CITY OF ALBUQUERQUE

August 15, 2023

Re: Martinez Retail Center
1021 Old Coors Dr SW
Traffic Circulation Layout
Engineer's/Architect's Stamp XX-XX-XX (L11-D071)

**TCL-1**

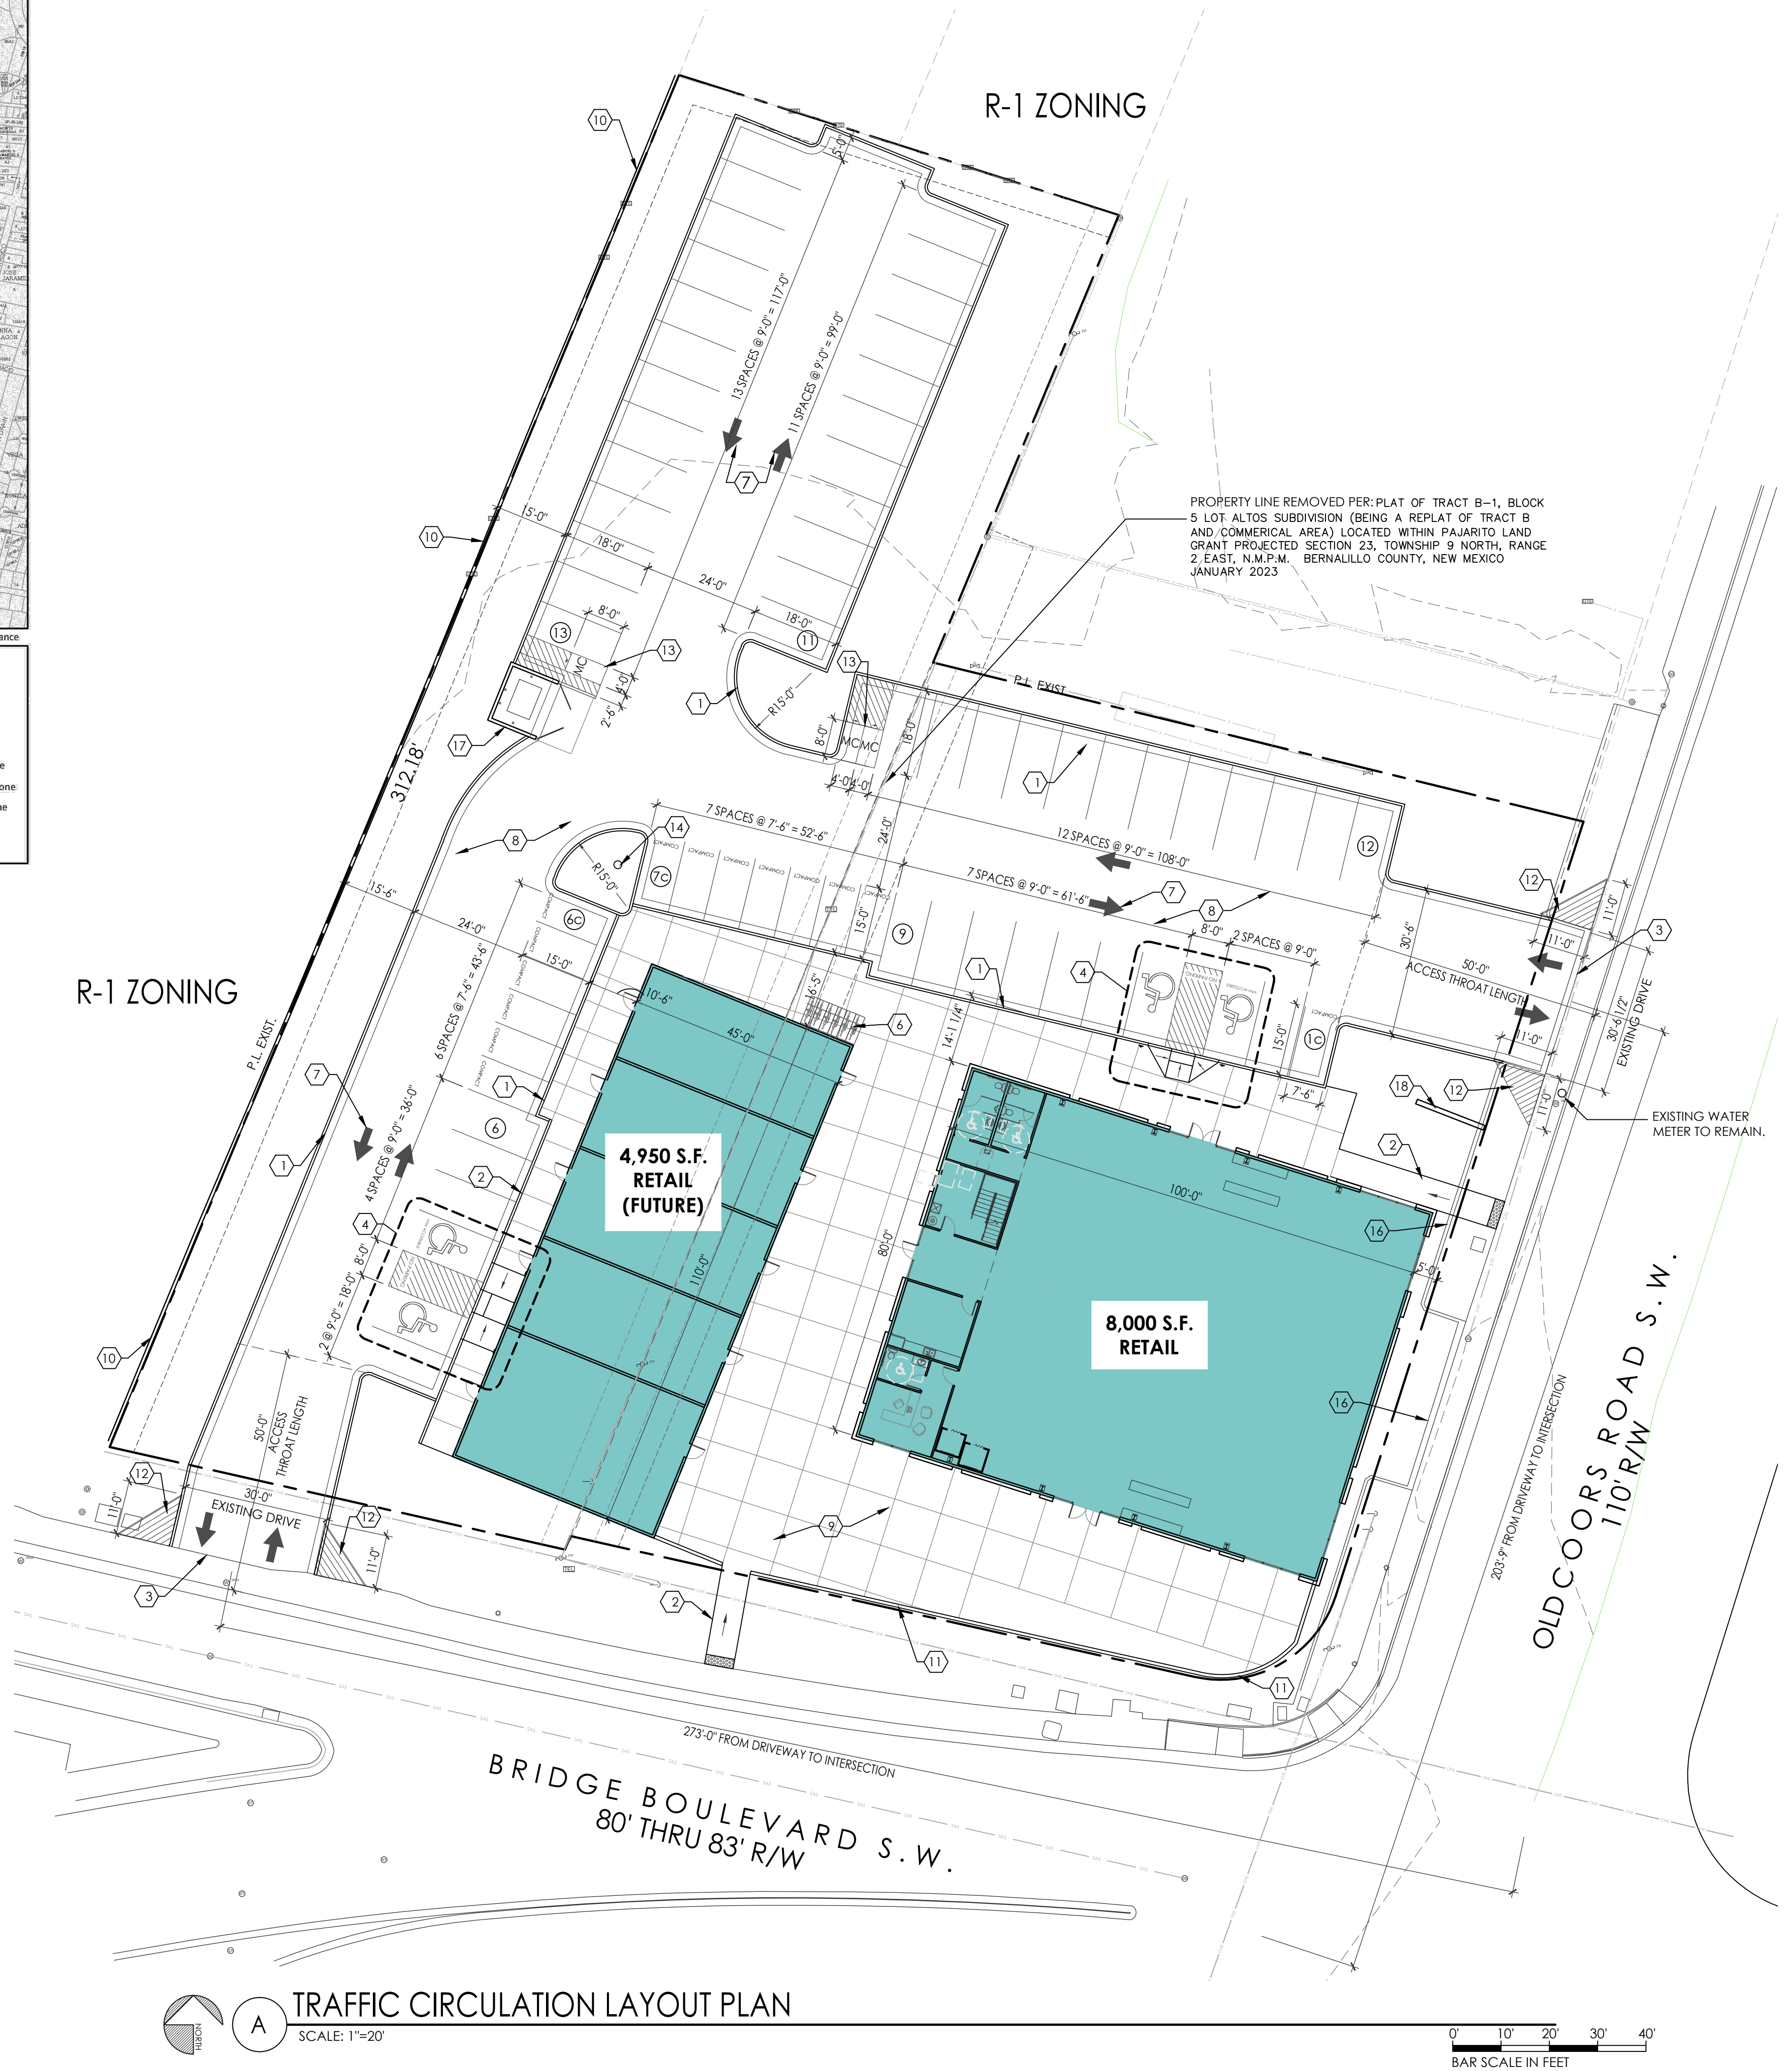
1. List the number of Motorcycle and Bicycle parking spaces required by the IDO.
2. Identify all existing access easements and rights of way width dimensions.

3. Clarify existing property lines and proposed property lines.
4. It appears there is a property line in the middle of the site plan, are you going to replat? Please address this concern.

5. Site accesses:
 - Per the DPM, Curb Returns rather than Drivepads are recommended on Arterials.
 - Per the DPM, A 50 ft. access throat length is required.

- 200 ft. is the minimum required distance from commercial site access points to the intersection. Please show this dimension on the site plan.
 - Are you going to close the existing drivepad off Old Coors? Due to the existing manhole, please contact Water Authority department (jshell@abqwua.org).

6. Keynote 2: please provide pedestrian pathway details (length, width, cross slope and running slope).
7. Provide details for the proposed interior ADA ramps.

8. The pavement marking "MC" should be shown in the opposite direction for motorcycles entering the parking space.
9. Per DPM, a 6 ft. wide ADA accessible pedestrian pathway is required from the ADA parking stall access aisles to the building entrances. Please clearly show this pathway and provide details.

10. ADA accessible pedestrian pathway should not be placed behind parking space or adjacent to a vehicular way. Vehicle and pedestrian/wheel chair conflicts should be avoided as much as possible.

11. Provide a copy of Fire Marshall AND Solid Waste Approval.
12. Please specify the City Standard Drawing Number when applicable.
13. Shared Site access: driveways that straddle property lines, or are entirely on one property but are to be used by another property, shall have an access easement. Please include a copy of your shared access agreement with the adjacent property owner.

14. Unused curb cuts must be replaced with sidewalk and curb & gutter. A build note must be provided referring to the appropriate City Standard drawing.
